Application H16-0871-24
Location Land adj Pilgrim's Pride Limited Fulney Lane North Spalding PE12 6EP
Proposal Change of use of agricultural land and development for Solar array of up to 1.64 MWp and associated infrastructure including connection to Pilgrim's Pride Factory adjacent north

Name Diane Gordon
Address SHDC Environmental Protection

Site Layout

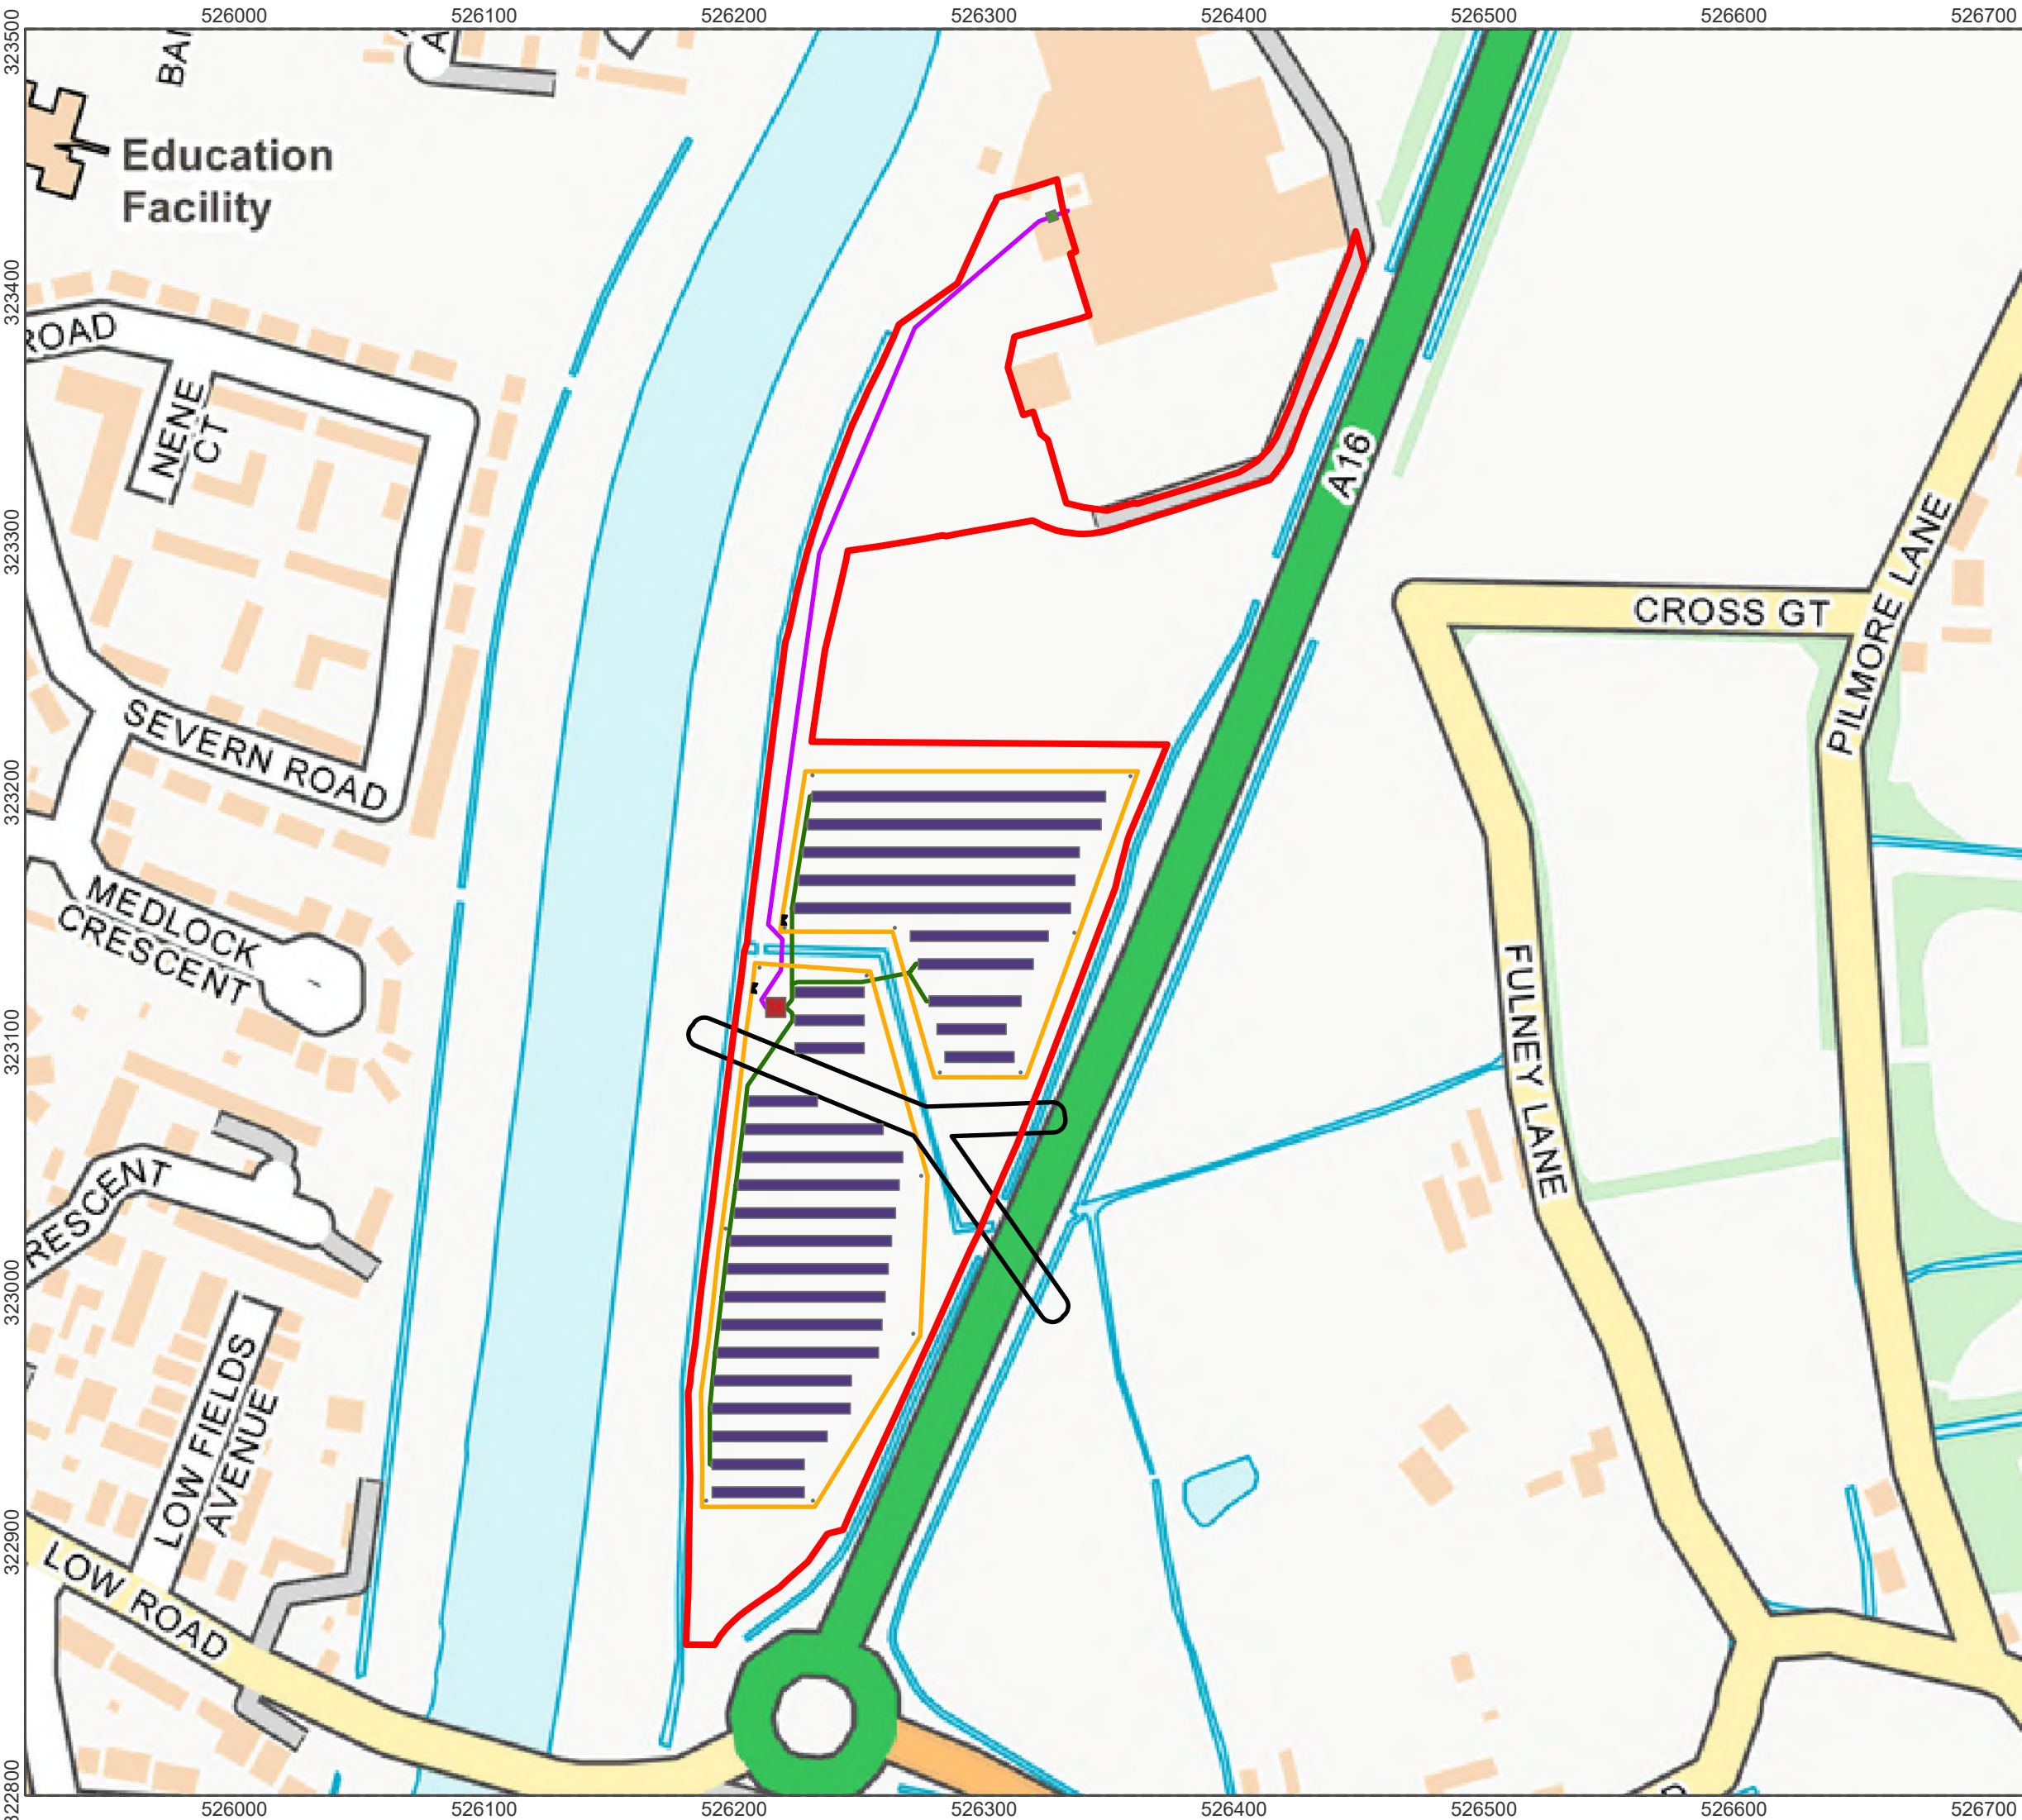
No observations on glint and glare report.
please provide noise ratings for transformer unit to determine whether any remediation is required to protect nearby residents prior to completion.
